Re: Victoria Buildings 10 King Street Clitheroe BB7 2EU | 3/2026/0382

These comments are on behalf of [REDACTED]

Client R.E.DAWSON PROPERTIES LTD		
Job Title Proposed Development of Victoria Buildings 10 King Street Clitheroe		
Drawing Title Proposed Elevations		
PLANNING		
Scale 1:100@ A1	Date Jan 2026	Drawn KD

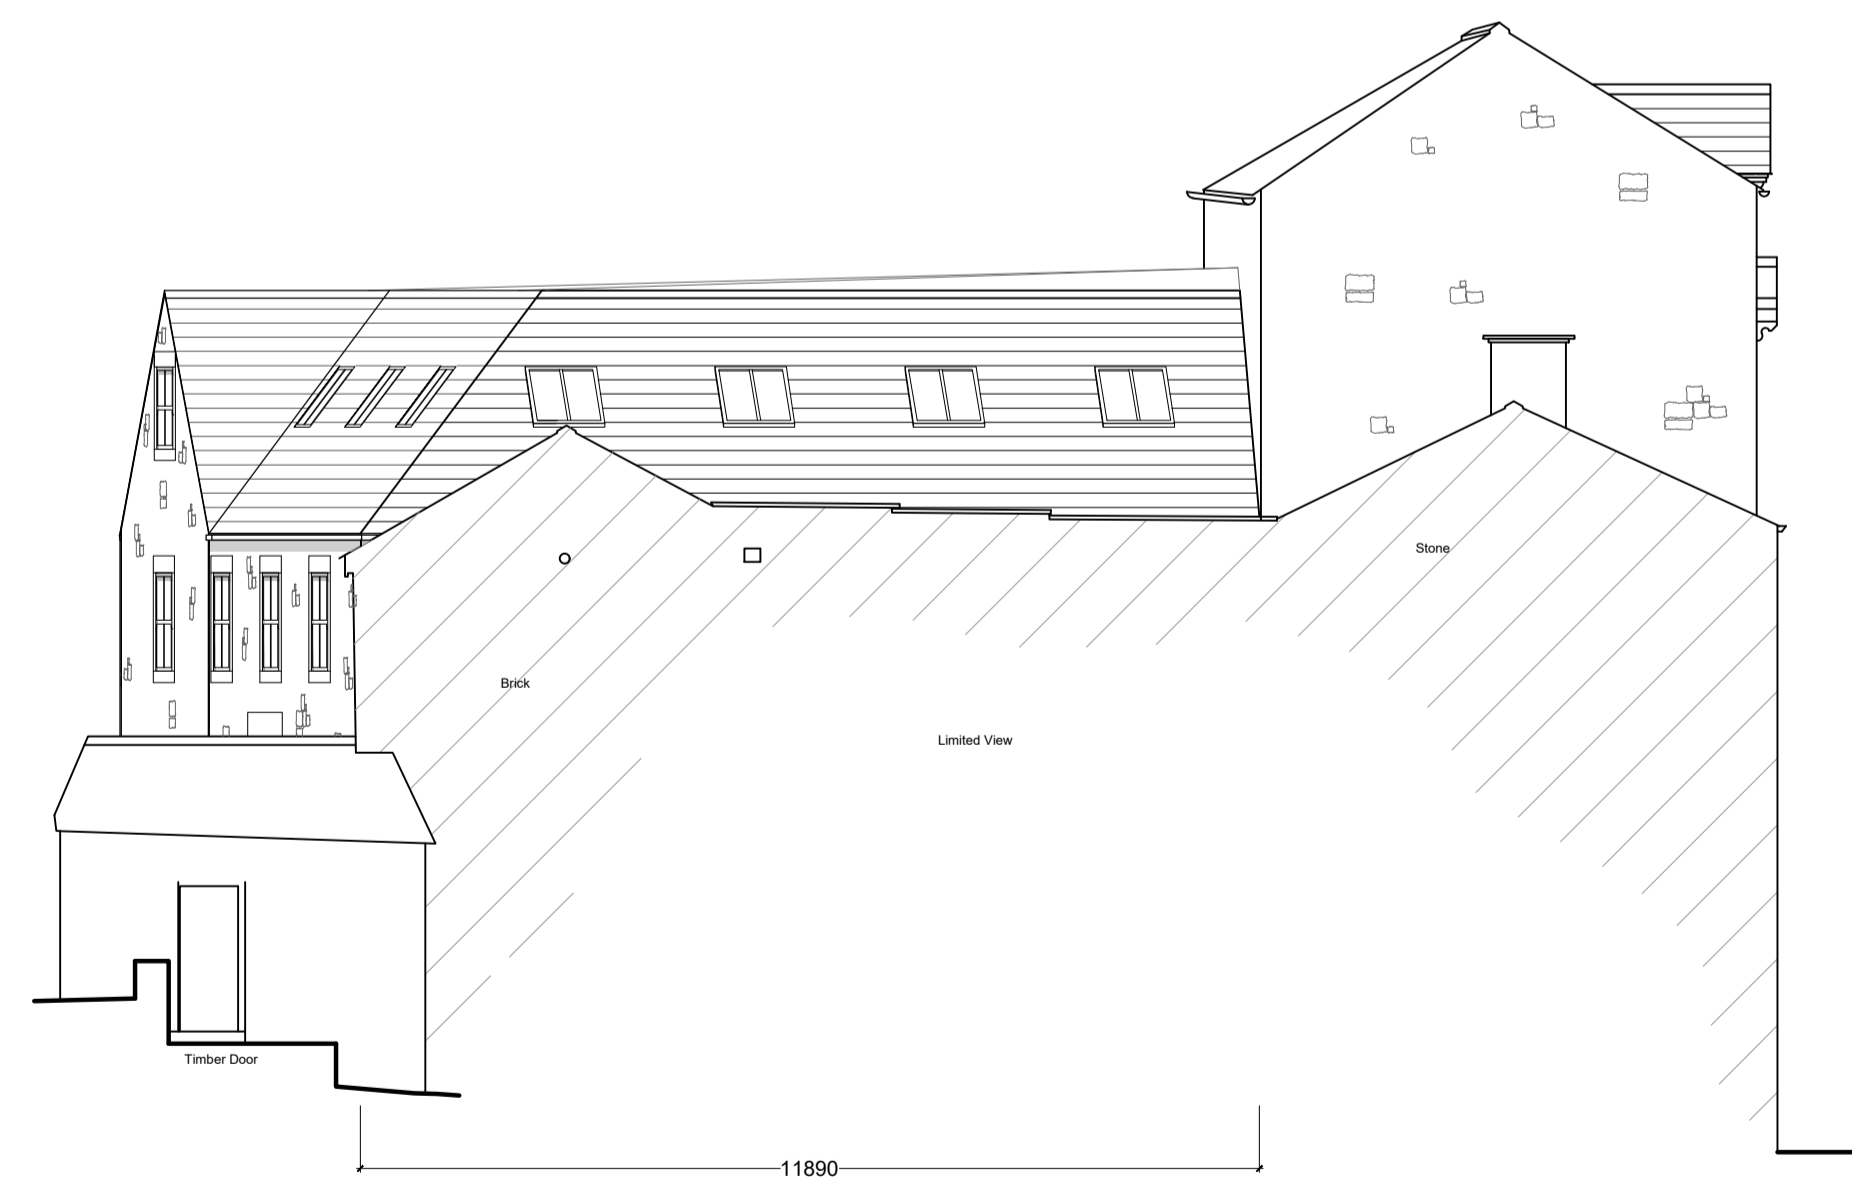
The proposed development to the building at the rear of 12 King Street would result in a high level of change to its character and harm to the character and appearance of the conservation area. The number and size of windows, combined with the larger and more steeply-pitched roof would introduce a level of over-domestication to the building which is at odds with its original purpose.

The justification for the number of windows is unclear from the application as there is no clear use of the building proposed other than 'Class E'. We do not think the harm to the conservation area has been properly identified or convincingly justified. We do not agree with the statement in the submitted heritage statement that the existing building is a 'harmful element' in the conservation area or that it makes a 'negligible contribution' to the overall character and appearance of the conservation area due to its mostly mundane and utilitarian. The utilitarian characteristics are exactly why the building is an important part of the conservation area and the legibility of the historic streetscape.

We would encourage the applicant to revisit the proposals and to design a less harmful and intensive scheme which is more sensitive to the character of these historic backlot areas of Clitheroe town centre. The building could be brought back into use in a more sensitive way, while retaining the utilitarian character of traditional backlot building and enabling the legibility of the medieval town plan.
